Drainage Addendum

Site: Land to the North of Arundel Road, Fontwell, West Sussex BN18 OSF

Client: Harlequin Developments

- 1.1.1 This Drainage Technical Note (TN) has been produced in response to the latest response from West Sussex County Council (LLFA) dated 5th June 2026 in relation to Planning Application Reference: WA/18/26/PL concerning a proposed residential development of up to 64 units on Land to the North of Arundel Road, Fontwell, West Sussex BN18 OSF.

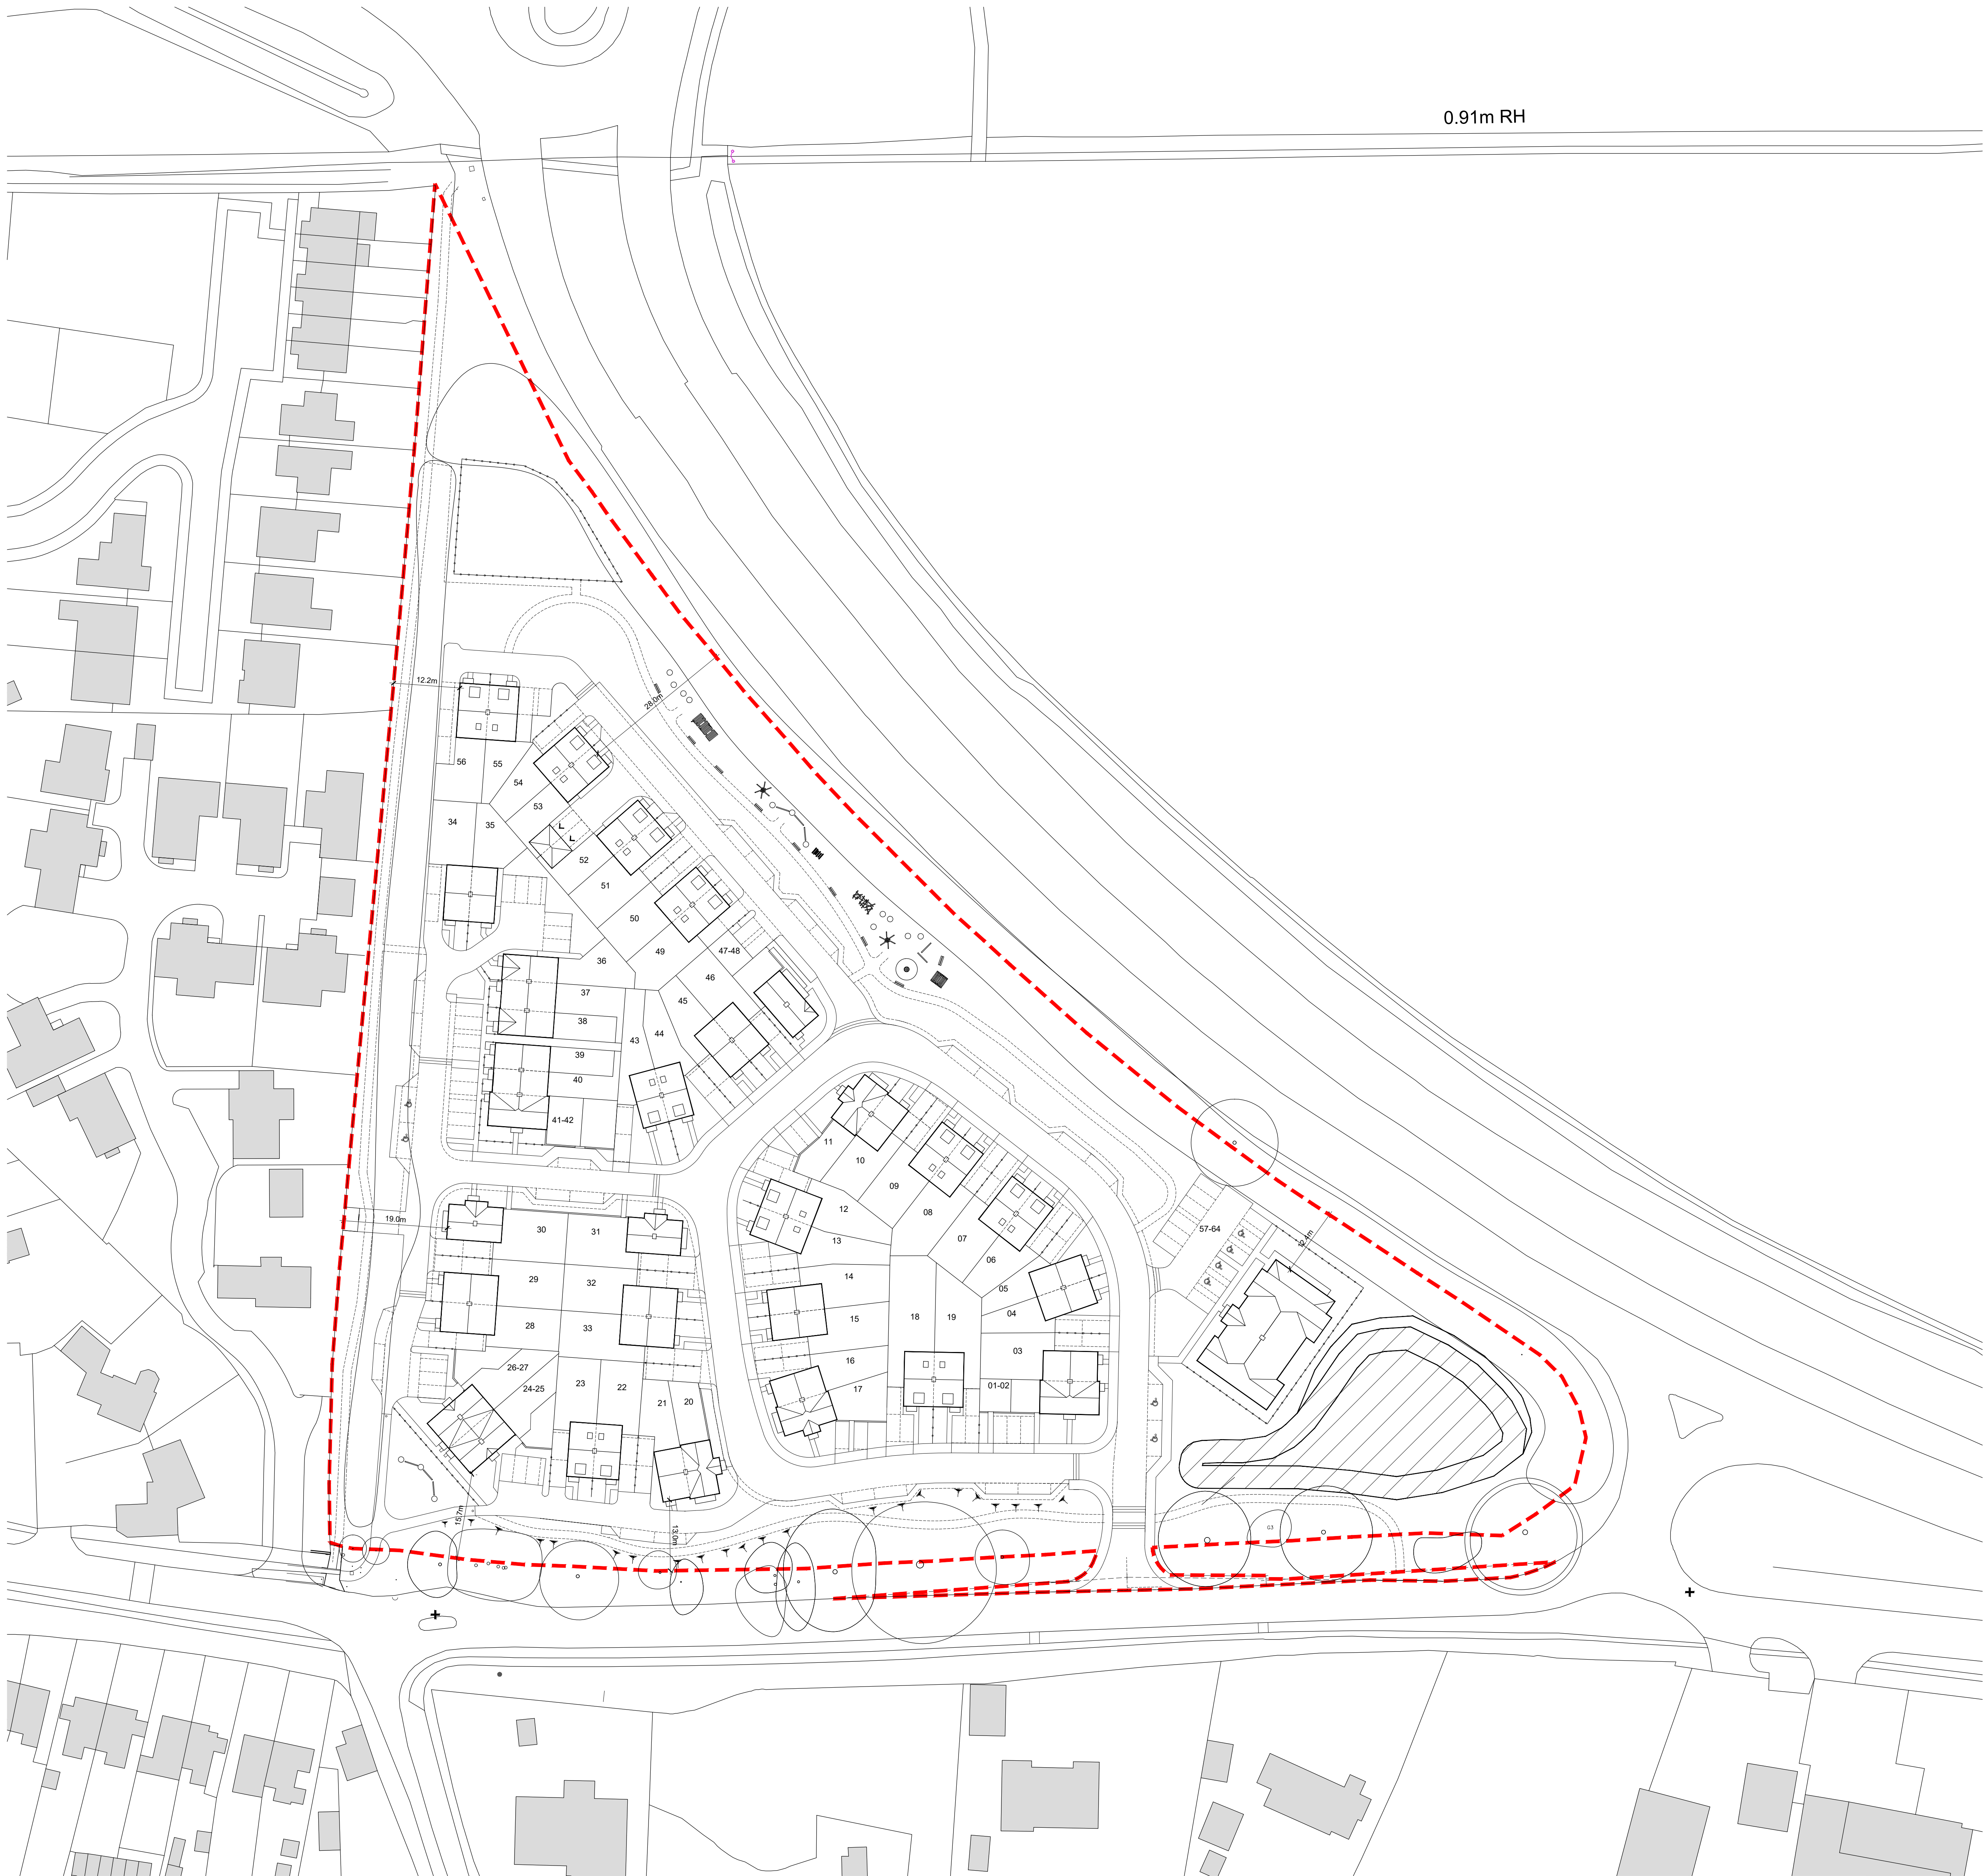
"While water butts are mentioned in 1.3.4 for rainwater harvesting, these are not included in the Drainage Strategy Plan. To ensure these are included during construction, we would recommend a note on the location of the water butts is added."

- 1.2.2 Water butts are shown on the detailed site layout drawing contained in **Appendix B**. A note has also been added to the drainage strategy drawing, contained in **Appendix C**.
